10 November, 2017
Our Ref: 24163 KW
Your Ref: MP05_0024

RESPONSE TO OEH COMMENTS - REQUEST TO MODIFY A DEVELOPMENT APPROVAL UNDER SECTION 75W OF THE EP&A ACT – MAJOR PROJECT 05_0024 FOR A STAGED 102 LOT RESIDENTIAL SUBDIVISION – (FORMER LOT 171 DP 1081810) NOW LOTS 117/118 DP 1226471 HIGHVIEW DRIVE DOLPHIN POINT FOR MALBEC DOLPHIN POINT PTY LTD

Figure 2 - The original and revised location of Scrape Sites 4A, 4B, 5A and 5B (source: allen price & scarratts)

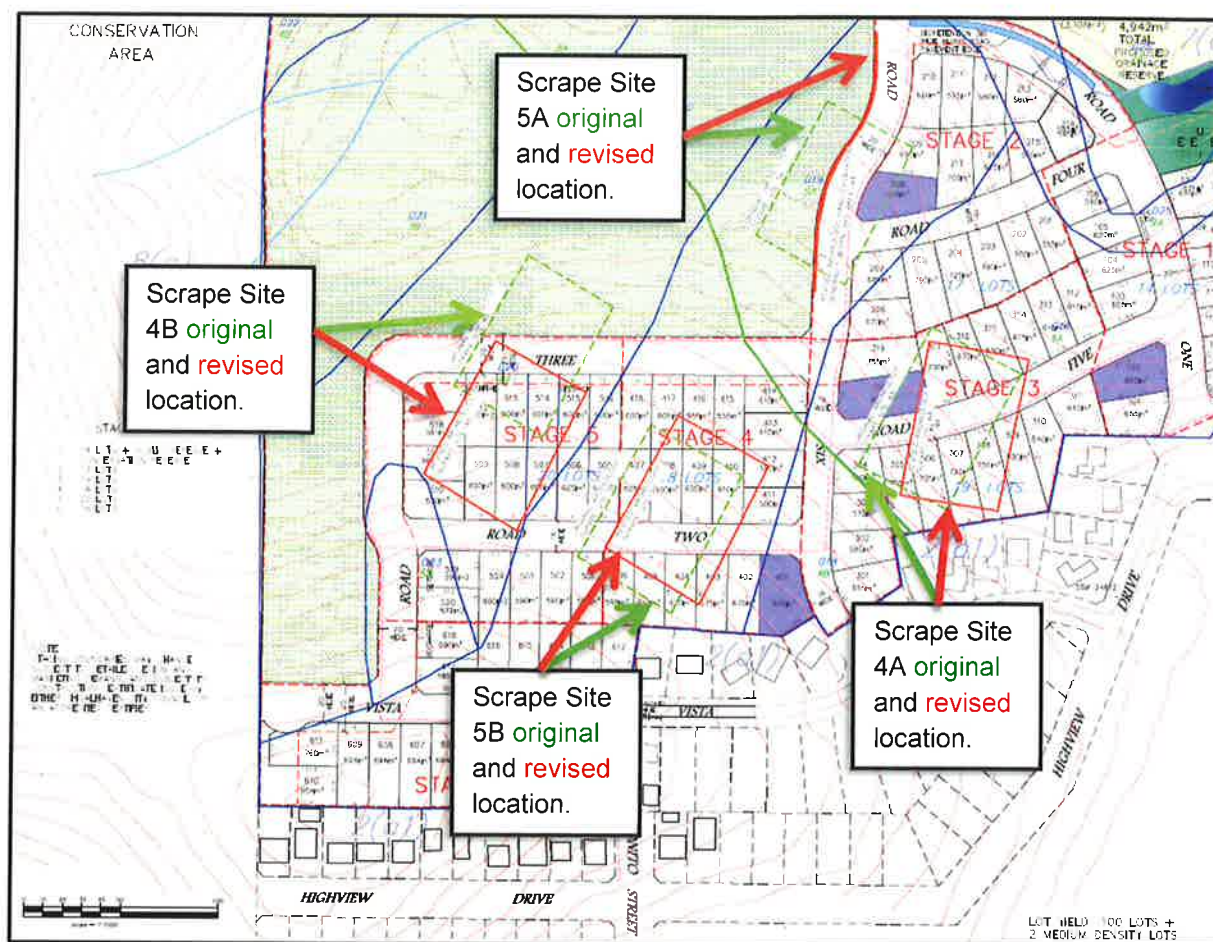
5A

Archaeological hand excavation should be conducted in the small part of landform unit 5A that appears to be within Stage 3/4 construction footprint (and therefore, we assume, has not been impacted). We suggest that the excavated area should be 4 – 25m sq. We also suggest some archaeological test pits are hand excavated within the conservation zone of the proposed 5A square as shown in Figure 1 of the revised AHMP dated March 2016. This should allow some of the research questions to be addressed, although a smaller area would be excavated than was stipulated in the AHMP.

4B

We suggest relocating the proposed scrape at 4B to further south so that it is still within the 4B landform, but also within the construction footprint (looks like this will be in Stage 5). The 4B excavation methodology set out in the AHMP should then be able to be implemented.

- It was generally agreed that the Scrape Site for the 4B area can be relocated fully into Stage 5 as a part of an amended AHMP.
- It was generally agreed that the AHMP be updated to include any administrative/reference updates as specified by OEH.

It was also agreed that the Scrape Site for the 4B area can be relocated fully into Stage 5 as a part of an amended AHMP.

We have also provided a suggestion for the 5A area being potential "test pits in the road reserve up to 1m from the fence/boundary to the conservation reserve. This 1m section should be relatively intact, and if smaller pits (as opposed to trenches) used, this may be an alternative. Pits would need to be away from posts (so as not to destabilise) and electricity lines identified before starting. This road reserve area has yet to be dedicated as public land so there is a narrow time frame to do this work ASAP if acceptable? We could start as soon as endorsement given if acceptable which would be endorsed in s75W?"
